Application No: FP/212/20/OUT

Site Address: Pipers Croft 6 The Loop Felpham PO22 7ND

Description of works: Outline application with all matters reserved for 1 No. 4 bed detached dwelling.

Thank you for your internet representation made on 16th November 2020 which has been recorded as an objection with the comments as follows:

Title
Block and Location Plans

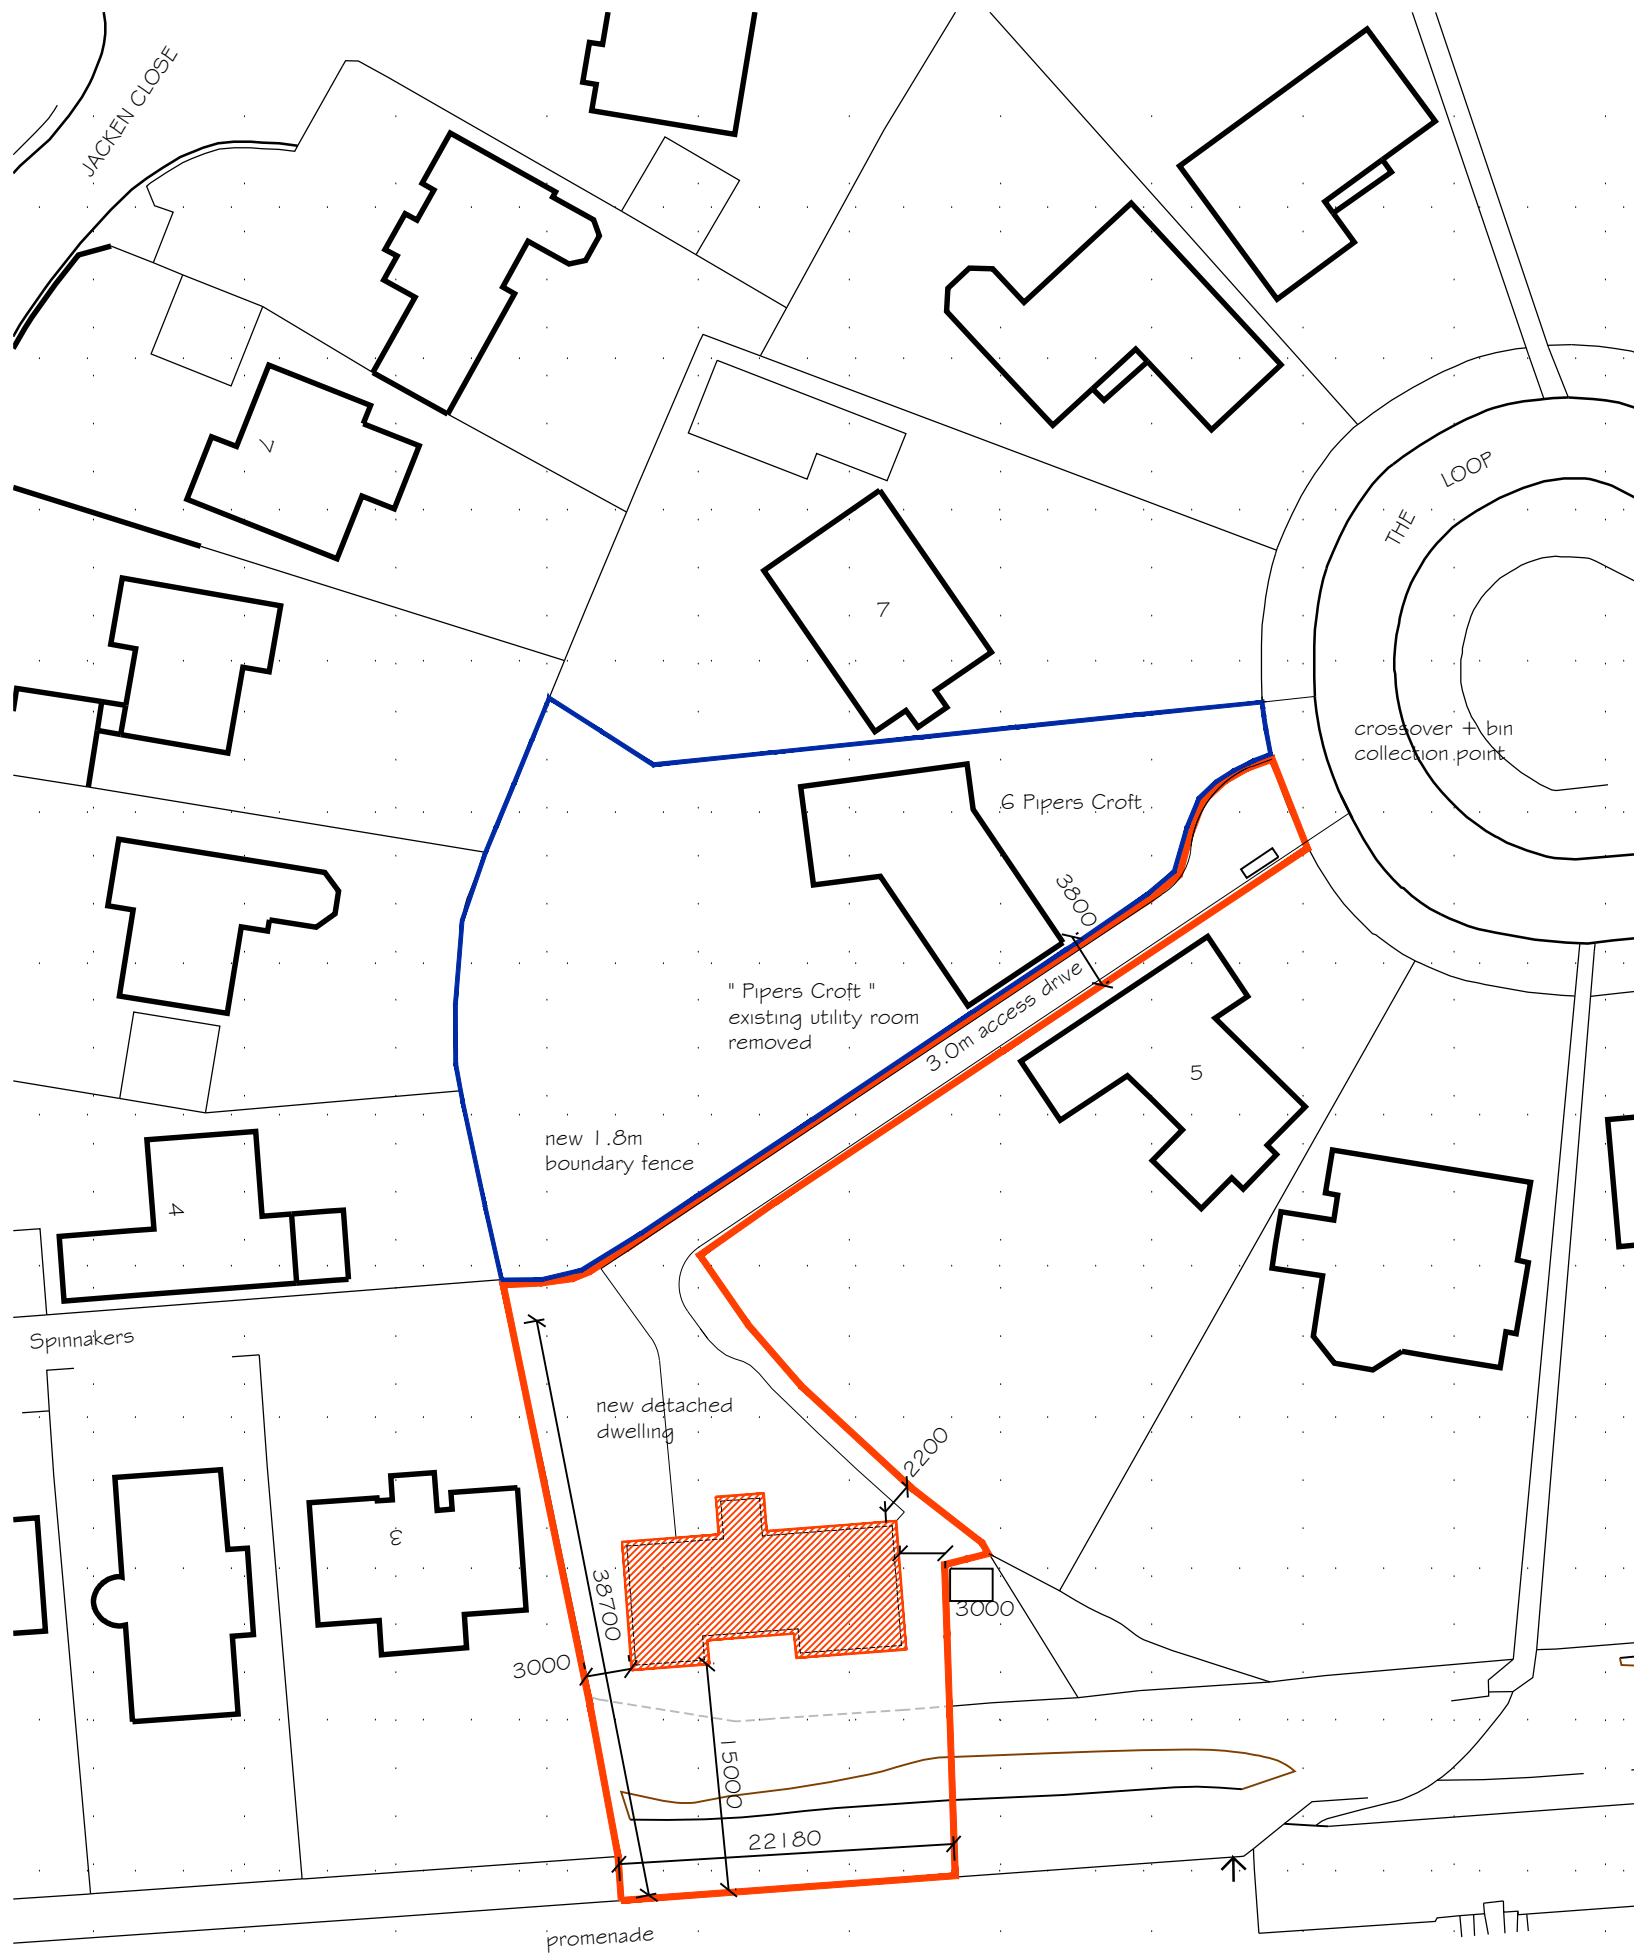
Our eastern boundary is immediately adjacent to the rear garden of no 6 The Loop. Our SE corner boundary abuts the NW corner of the new development plot proposed. As such this development will have a large impact on our property.

Flooding issues on the Summerley Estate have been well documented and the Council's Engineers are well aware that the garden of No 6 The Loop has a very large drainage pond and other infrastructure to help mitigate flooding issues. Any interruption of this would worsen the flooding situation. The proposed development would also add capacity to an already overloaded drainage infrastructure. (Please note that on 15/11/2020 raw sewage erupted for several hours from the manhole eastern end of Limmer Lane opposite 130 Limmer Lane, ref. 2601 -reported).

Jacken Close (Spinnakers) which overlook our two storeys. This deficit would be exacerbated by a proposed development to our southeast, increasing the gloom especially on the ground floor.

The proposed development will block our southeasterly view towards the sea from our bedroom (facing east) and equally our privacy.

The proposed plot is not immediately adjacent to The Loop. Consequently, vehicular access would be via a long drive through an existing garden increasing vehicular noise and pollution for neighbours.
